| Consultation Response from Emma Mills KC Landscape | |
| Application No: | 2023/91405 |
| Proposed Development: | Erection of foodstore (class E) with associated access, parking, servicing area and landscaping |
| Location: | Part of former St Luke's Hospital site, Blackmoorfoot Road, Crosland Moor, Huddersfield, HD4 5RA |

Appendix 6: Tree Impacts Plan

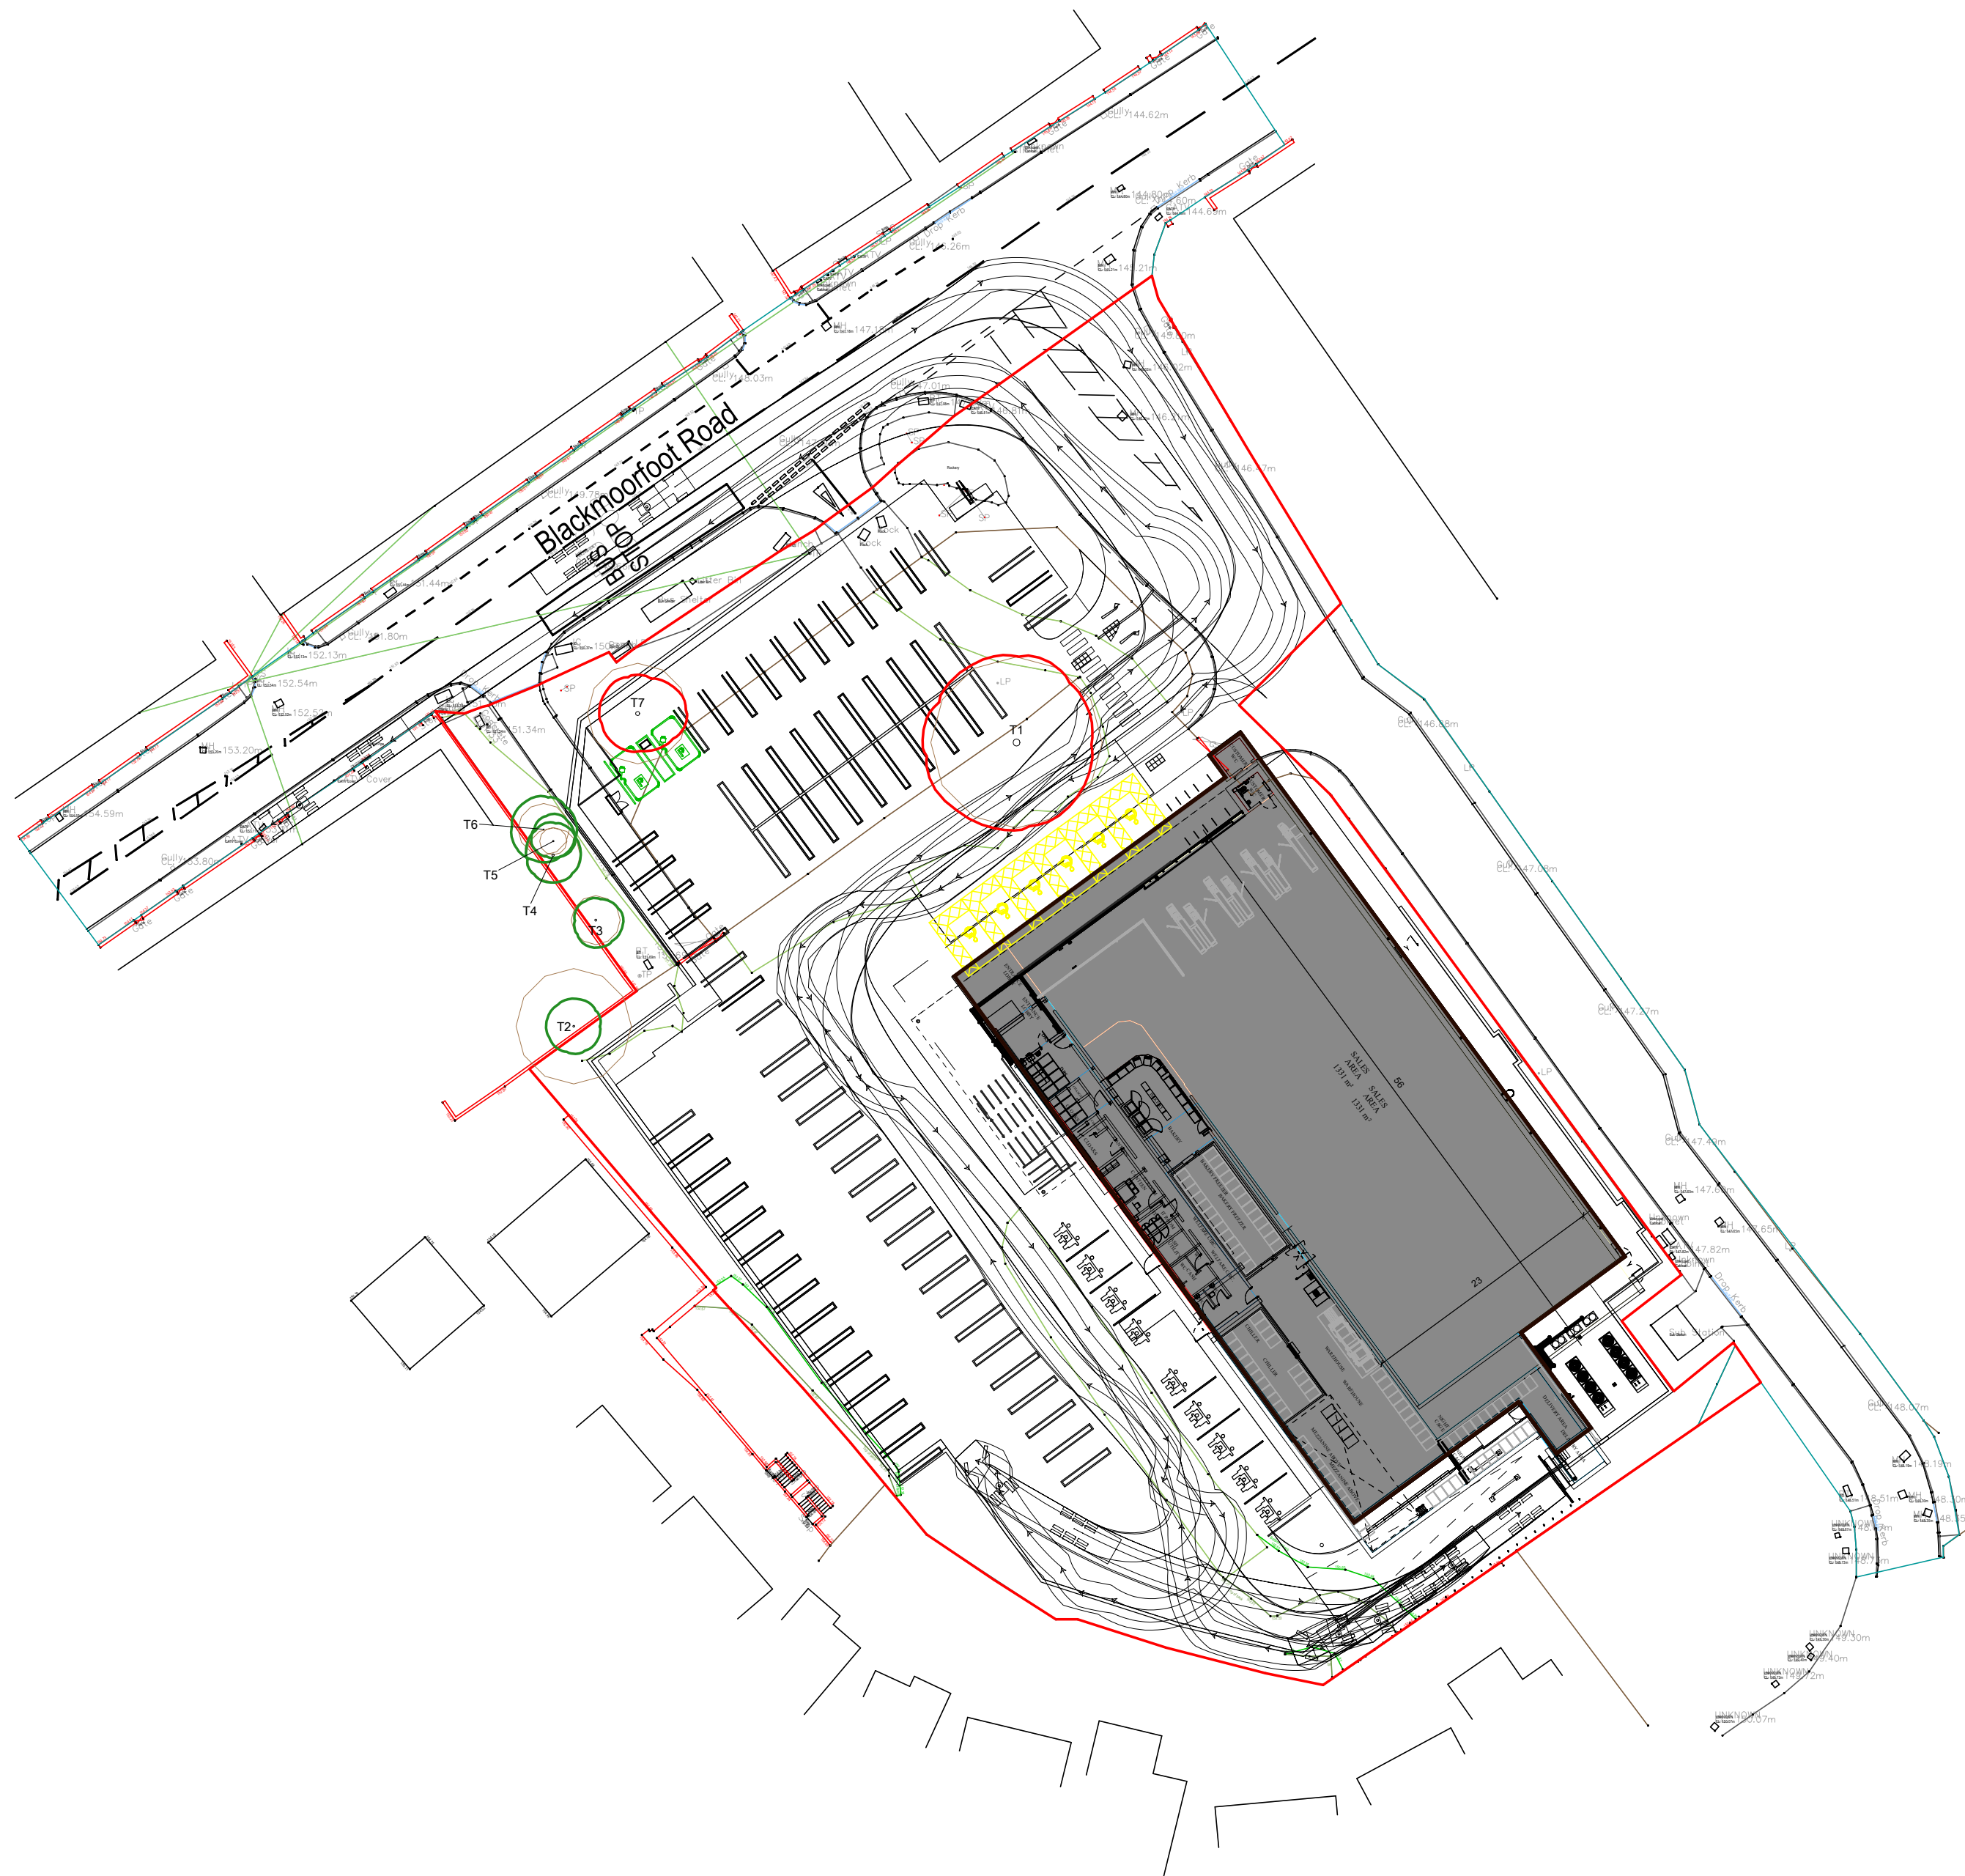
The Design & Access statement identifies two trees for removal (circled in blue).

It would seem from the Arboricultural Report that the removals include T1 a high quality and value Category A Sycamore, which is the major loss; T7 is identified in the Arboricultural Report as a diseased horse chestnut which will not survive.

(Note the tree survey identifies six trees for removal presumably four of these have already gone due to the development.)

Both the trees have TPOs

Figure 5.5 Proposed Landscape Plan

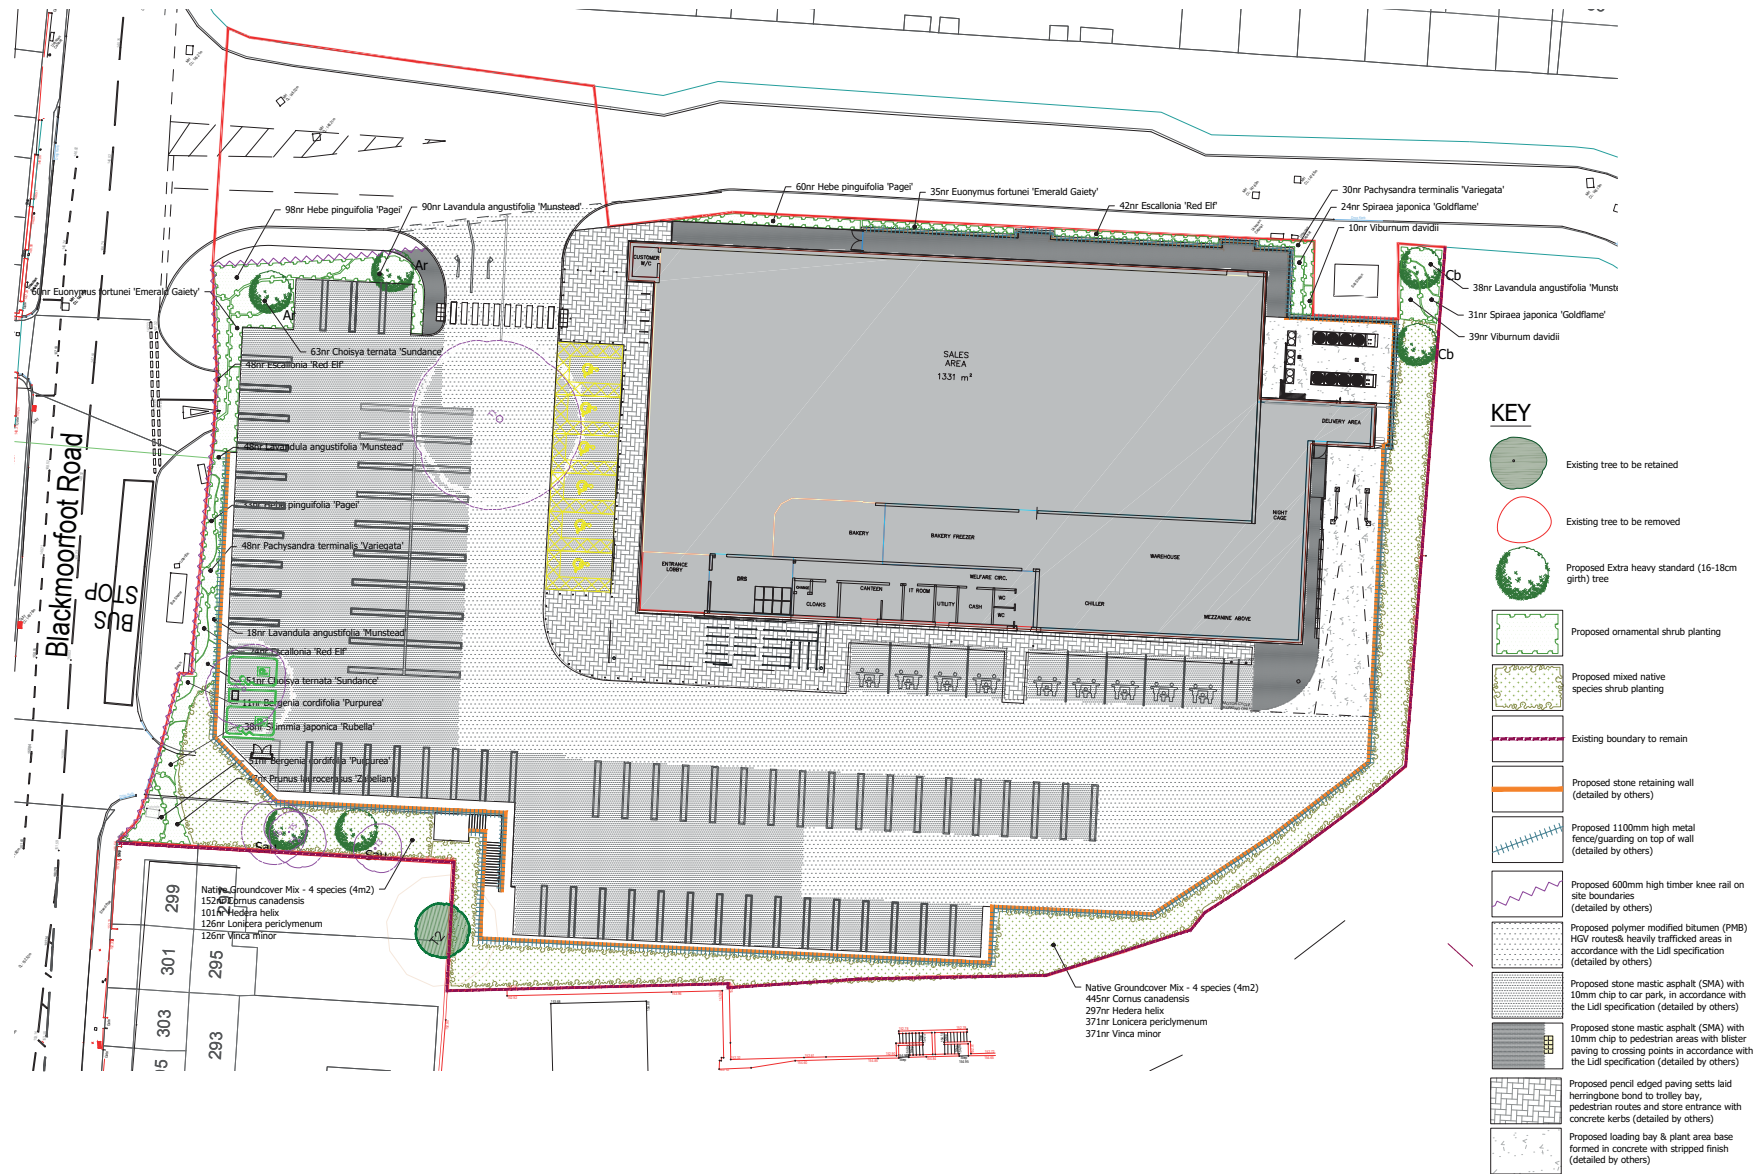
The proposals include six new trees (shown on the plan below), which are welcome. However, there are more opportunities for tree planting in the scheme, which as well as making up for the losses would additionally help the proposed development comply with policies and guidance regarding design, biodiversity, health and wellbeing and other relevant planning considerations.

In particular, we would like to see street tree planting along Blackmoorfoot Road and Turnstone Way. We feel the National Design Guide and revised NPPF, with their strong push for street tree

planting, should be recognised and potentially new tree planting to the street boundaries incorporated where possible. In addition, the proposed car park and front of the site is extremely vehicular dominated by hard surfacing and could be softened with the inclusion of carefully located and selected tree planting, potentially small fastigate varieties. [National Planning Policy Framework \(publishing.service.gov.uk\)](https://www.gov.uk/government/uploads/system/uploads/attachment_data/file/362822/National_Planning_Policy_Framework.pdf). Also, refer to item 2 below.

To be convinced of the sustainability of all the locations for the new trees, we would want to see details of ground preparation including tree cells and/or appropriate root barrier systems where space and soil volume is very restricted and/or close to hard surfacing. Additionally, we would anticipate all new tree planting within 5m of the adoptable highway to include adequate root barrier, clearly identified on the proposed landscape plans.

The proposed soft landscaping to the site is welcome and we would require clarification of the proposed long term maintenance and management of the planting scheme, particularly as the planting plan includes *Hedera helix*, which although not listed as invasive, can be vigorous and has the potential to become invasive. Consideration needs to be taken especially where planting near to borders residential housing (e.g. as highlighted in yellow).

To be satisfied with the proposals we will need to see amendments to the layout as above to improve the landscape scheme and incorporate mitigative tree planting for the loss of existing trees on the site, and inclusion of street tree planting, together with a management plan and condition covering any replacement planting for min, 5 years.
